Active
Travel
England

Your Ref: 22/00747/OUT
Our Ref: ATE/23/00246/OUT
Date: 28 July 2023

Active Travel England Planning Response Detailed Response to an Application for Planning Permission

Site Address: Land at Bicester Road, Kidlington

Status		Status Date
Information		Feb 2022
Drawn	Checked	Date
HG	AE	22.02.22
Scale	Number	Rev
As shown	10669-SK-05	F
0 10 20 30 40 50		
METRES

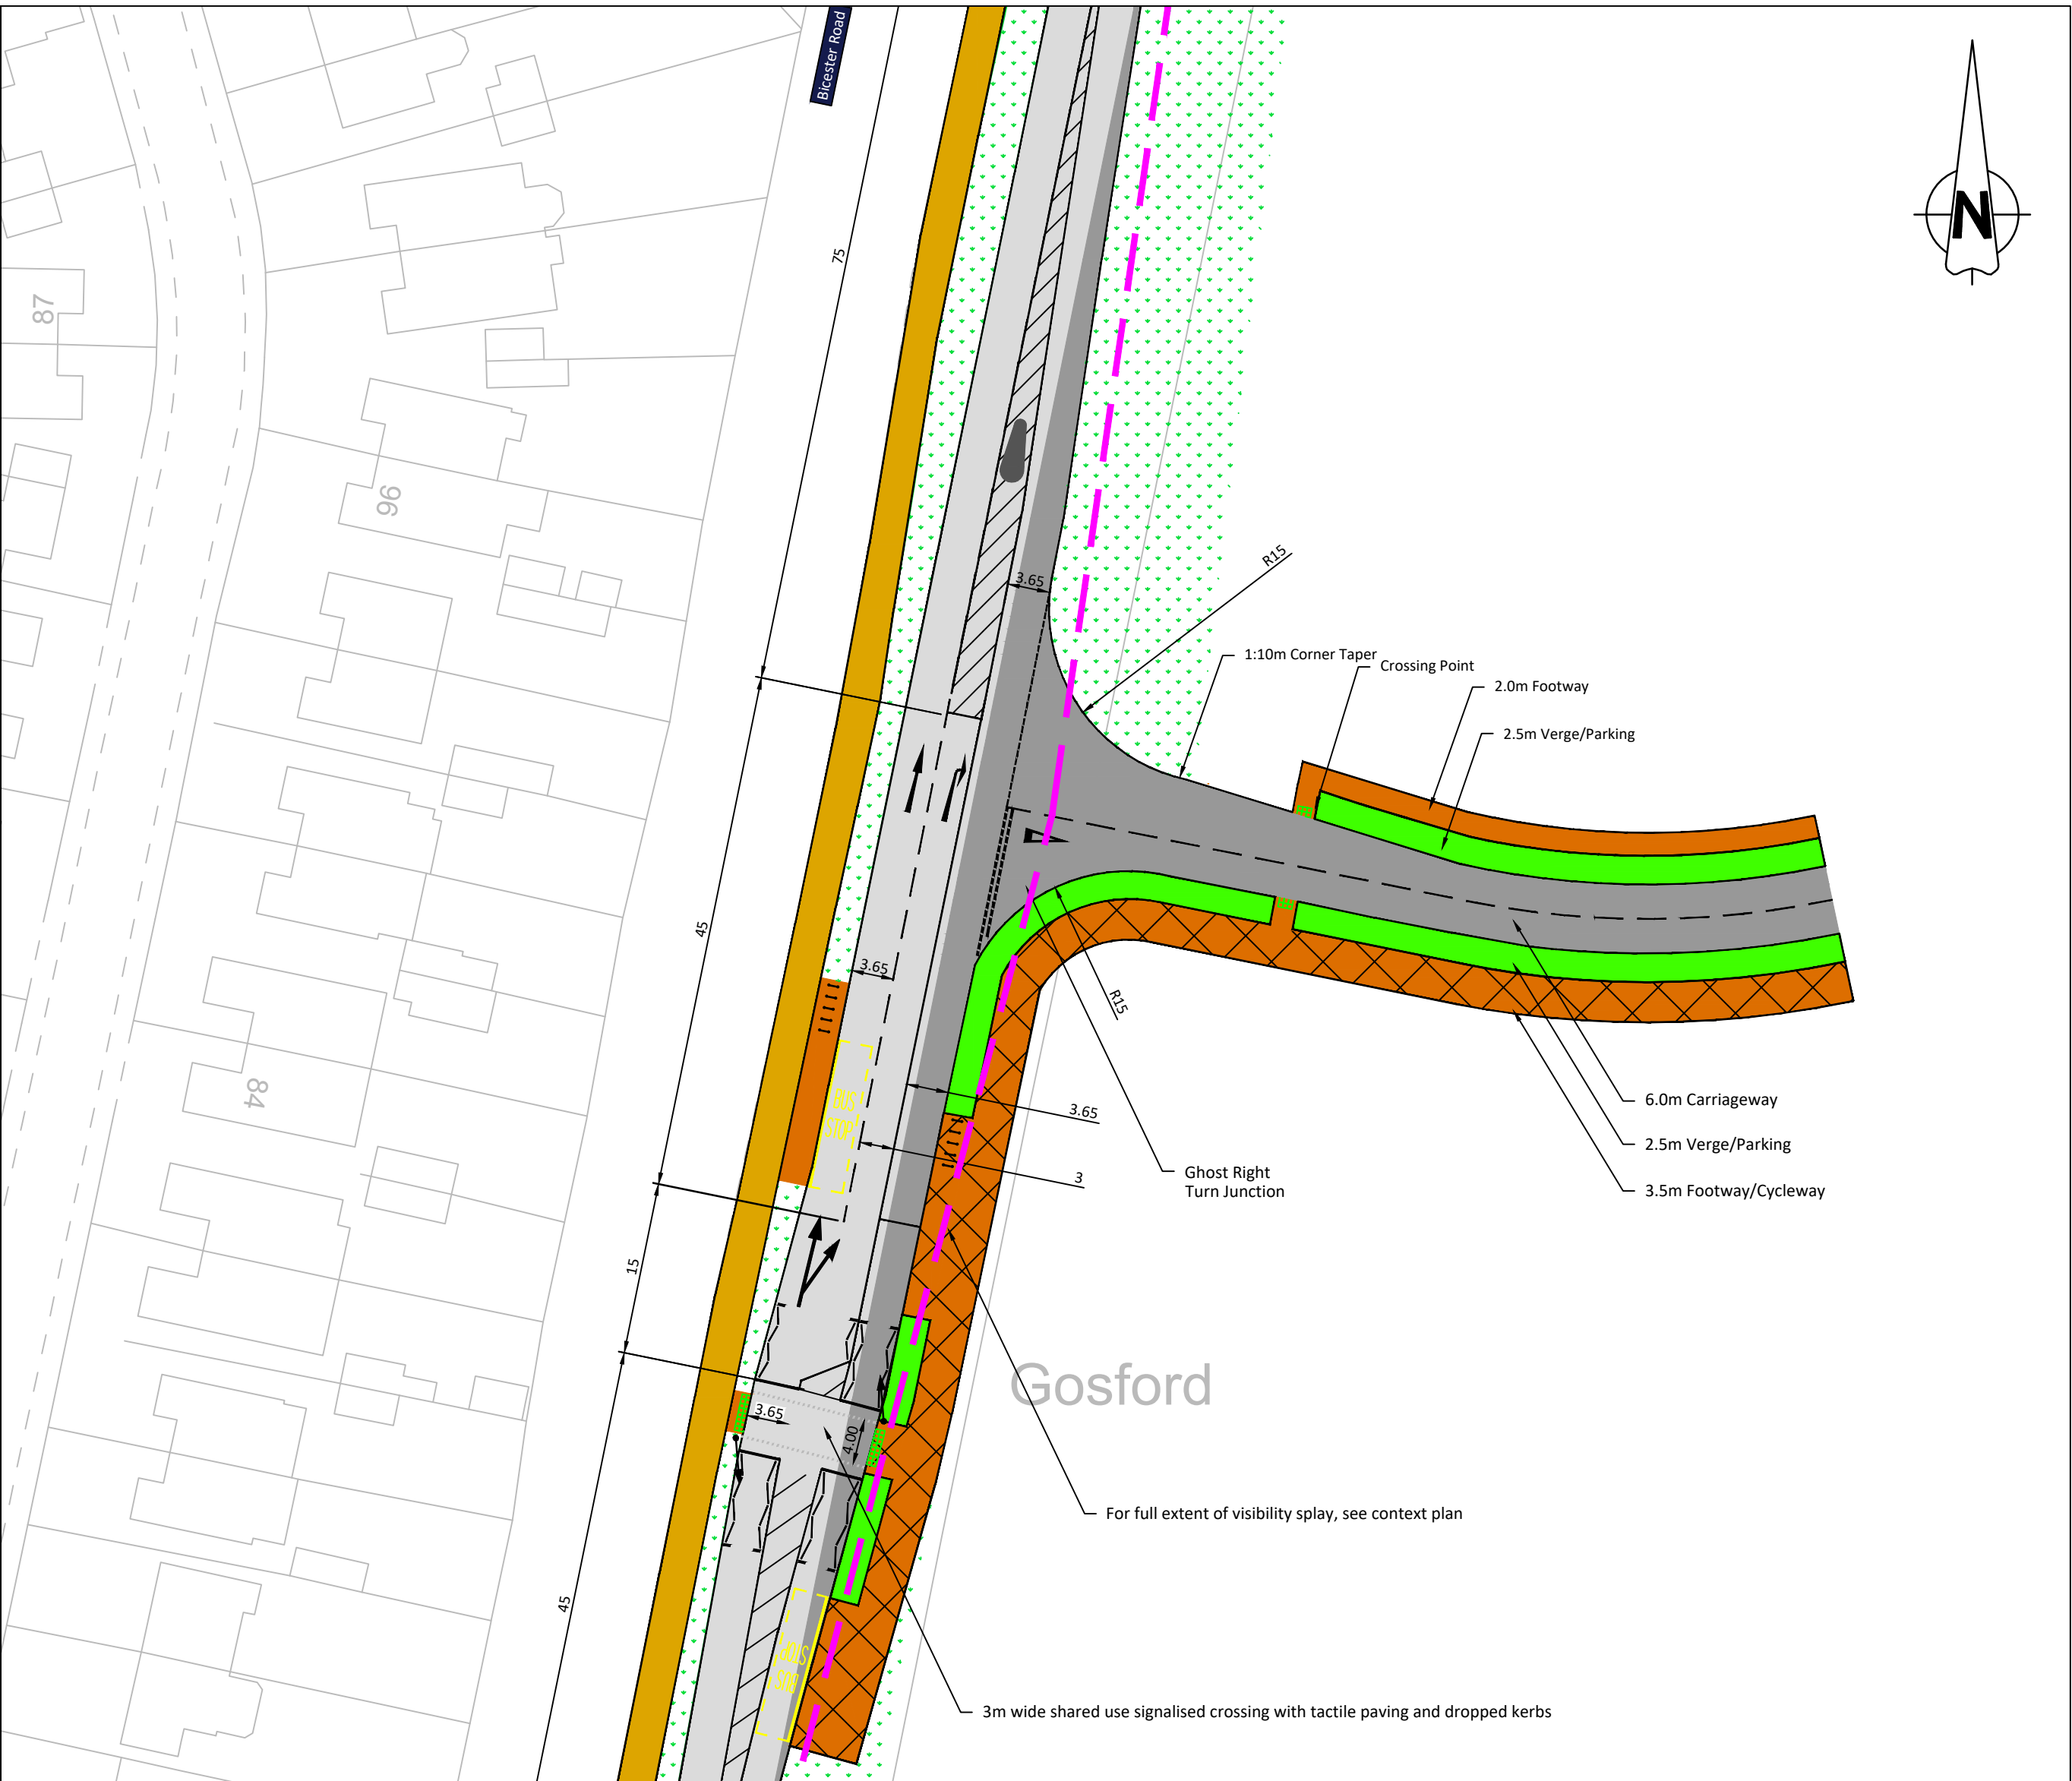
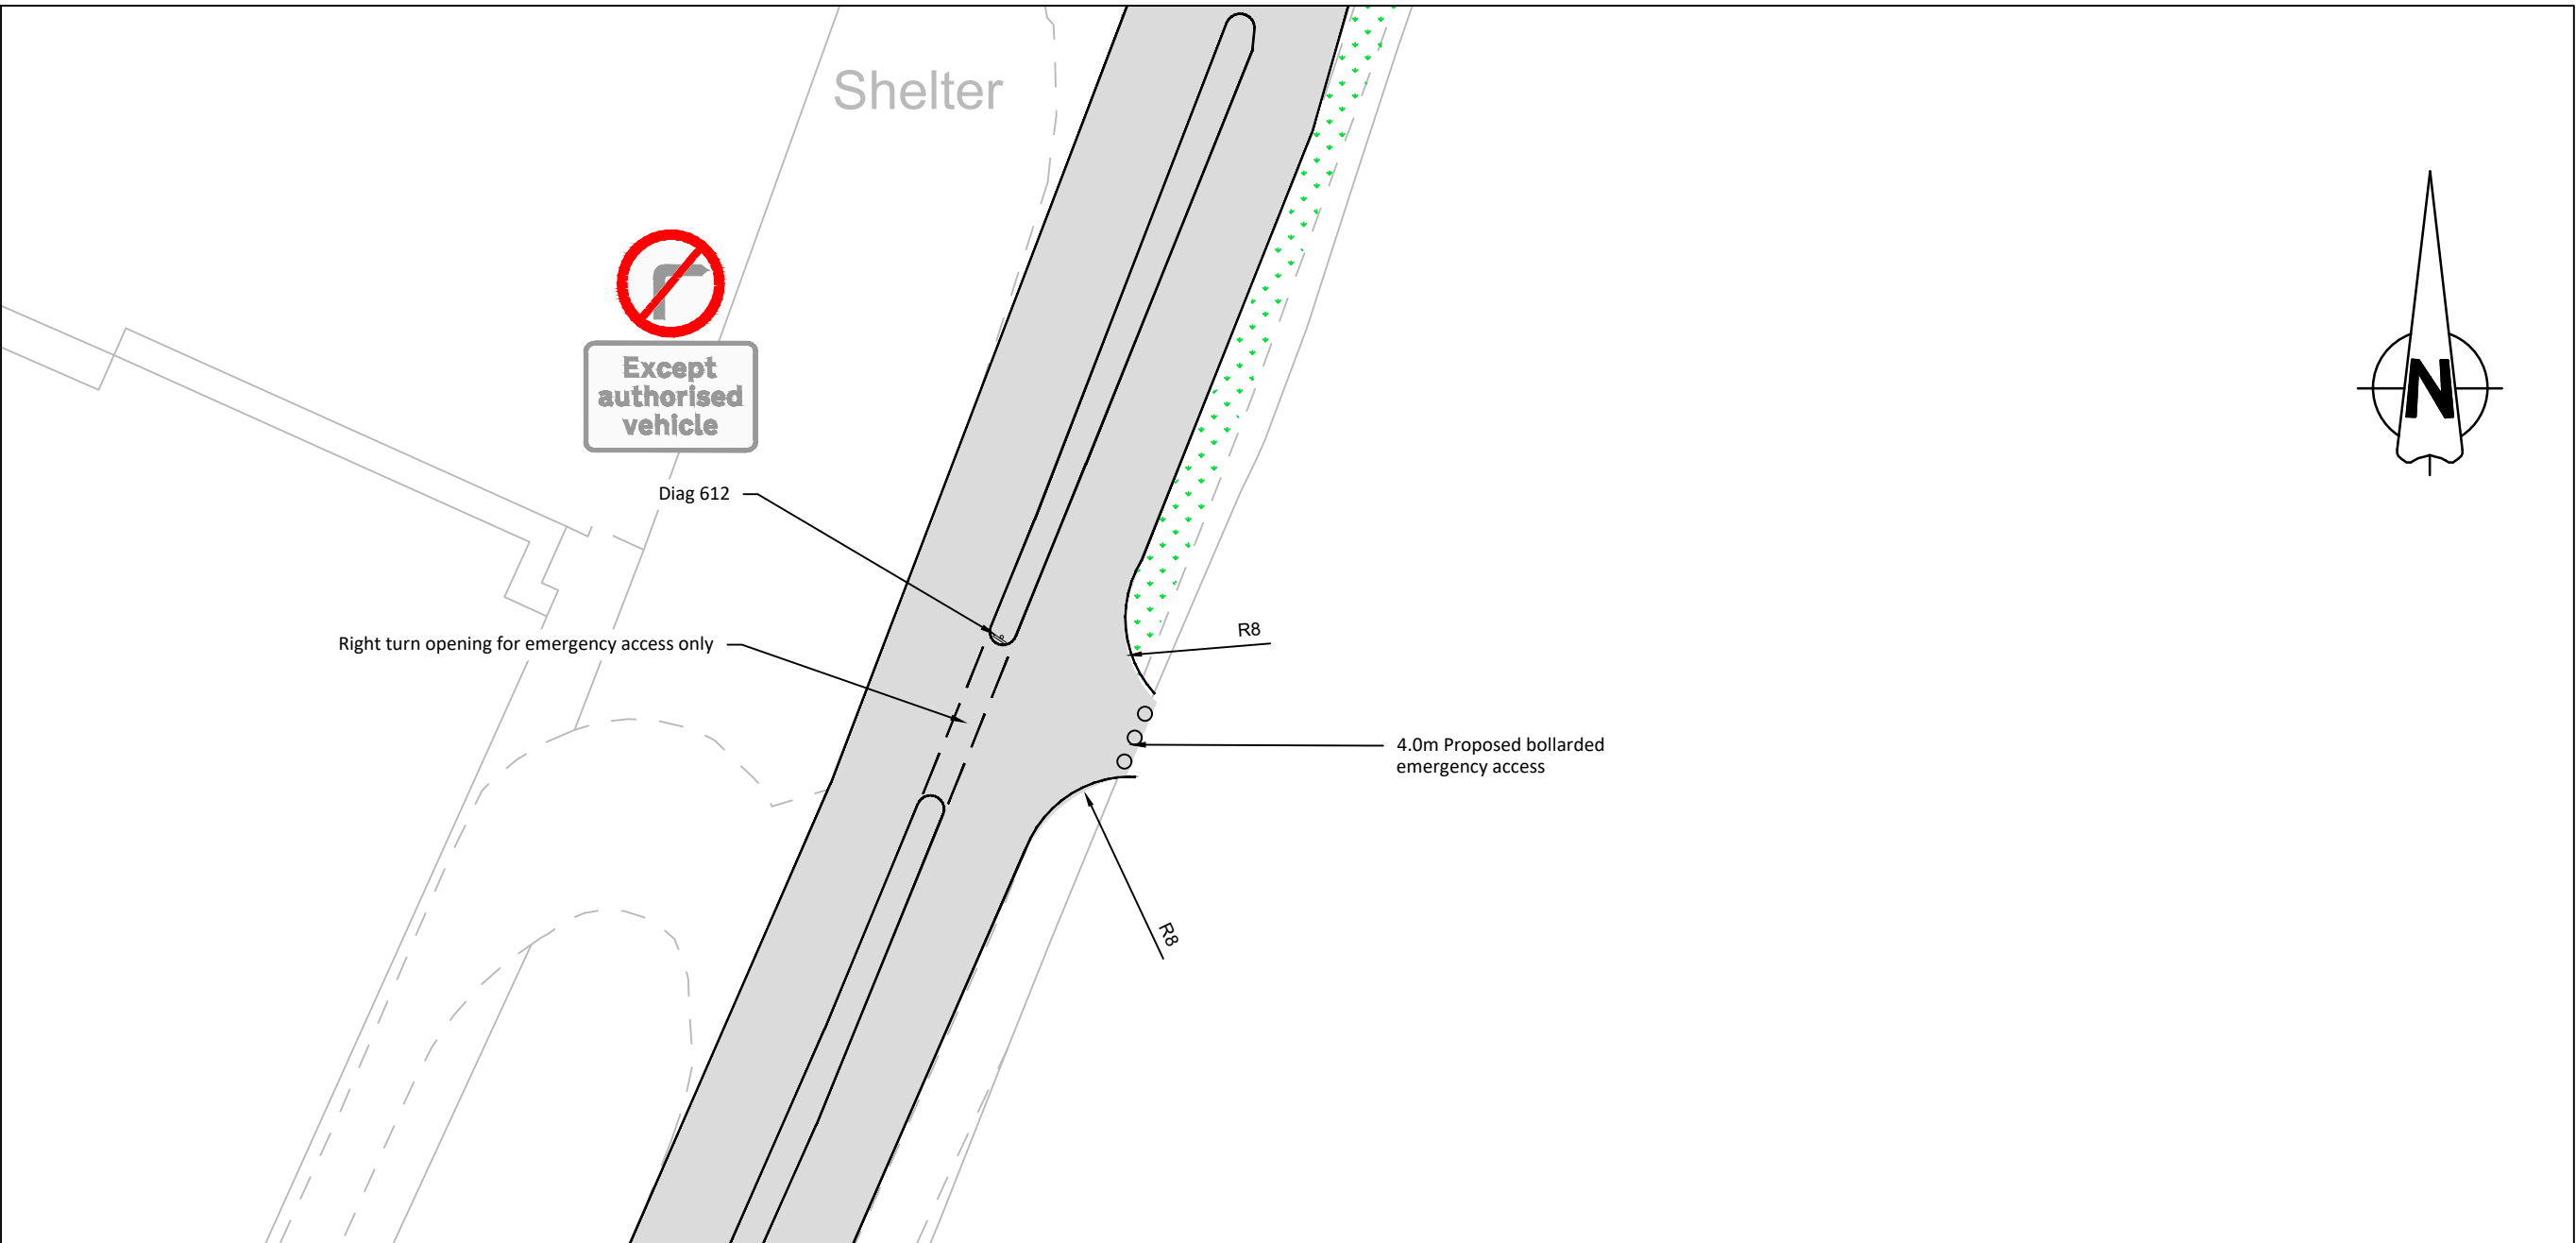
ATE notes that the pedestrian and cycle movements would be catered for through on and off-carriageway provision. However, the segregation provided to walkers, wheelers and cyclists is not clear. Bicester Road is currently limited to a single shared footway/cycleway on its western side. It requires users to cross the carriageway whether they are travelling north into Kidlington or South into Oxford. It is noted from the Transport Assessment that crossing points are to be provided across Bicester Road to access the existing footway/cycleway, and the location of a crossing is shown on drawing 10669-SK-05 included in the Transport Assessment, but the type of crossing is not specified. This design requires further consideration in accordance with LTN1/20.

In accordance with paragraph 104 of the NPPF, Active Travel England notes the location of the proposed pedestrian crossing in the Transport Assessment (drawing 10669-SK05) and would welcome further detail on the type of crossing to ensure its suitability for all users.
